**Consultation Response from KC,
Highways Development Management****2024/91524 Land at Old Lane /Taylor Lane, Scapegoat Hill, Huddersfield, HD7****Erection of two detached dwellings****Date Responded: 19-8-2024.****Responding Officer: Mark Berry.****Responding Ref: 1-45-27.**

This application seeks approval to the erection of two detached 4 bedroomed dwellings with single integral garages at land at Old Lane /Taylor Lane, Scapegoat Hill, Huddersfield.

PROJECT:	Plot 1, Taylor Lane, Scapegoat Hill, Huddersfield			
CLIENT:	Mr. S. Gaunt			
DRAWING:	Proposed House Type - Floor Plans			
DRAWN BY:	GG	CHECKED BY:	--	CREATED: 22/05/2024 SCALE: 1:100 @ A3
STATUS:	Developed Design		DRAWING No: 1483/P-101	REVISION:

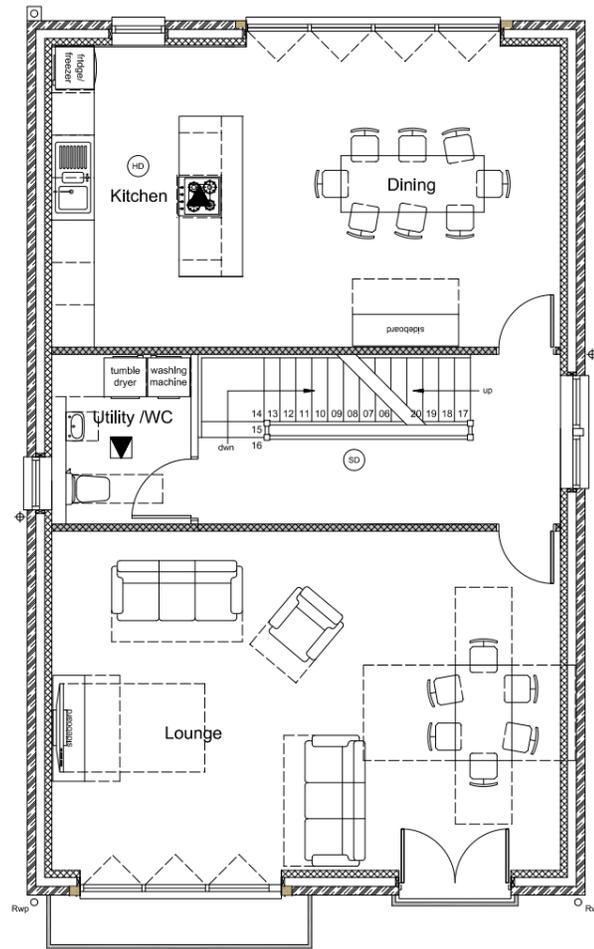
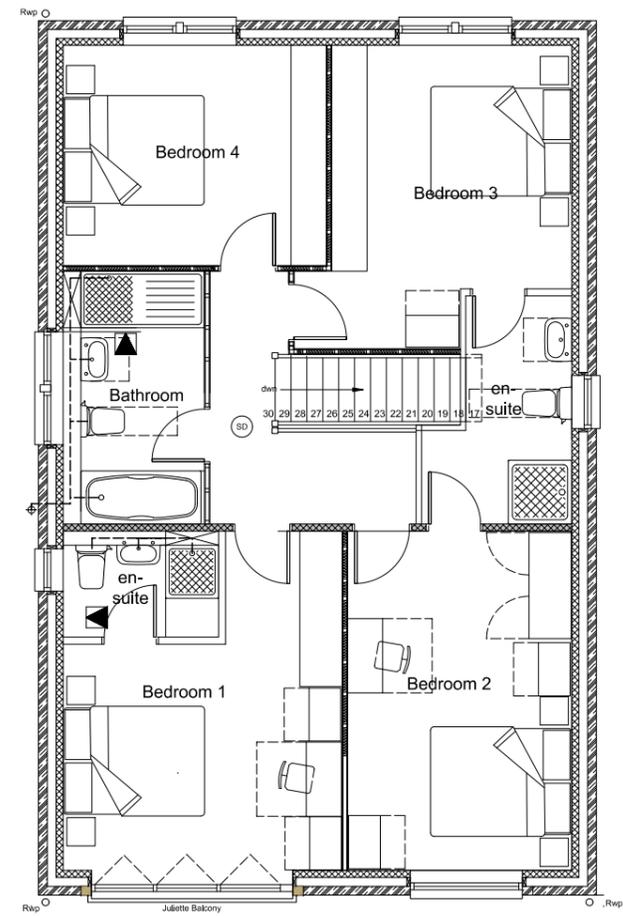
1, Parking to plot 2a. This is a 4 bedroomed dwelling, and 3 off-street parking spaces are therefore required to meet recommended standards. The integral garage and driveway which scales only 9 metres in length are not likely to be sufficient to accommodate 3 vehicles.
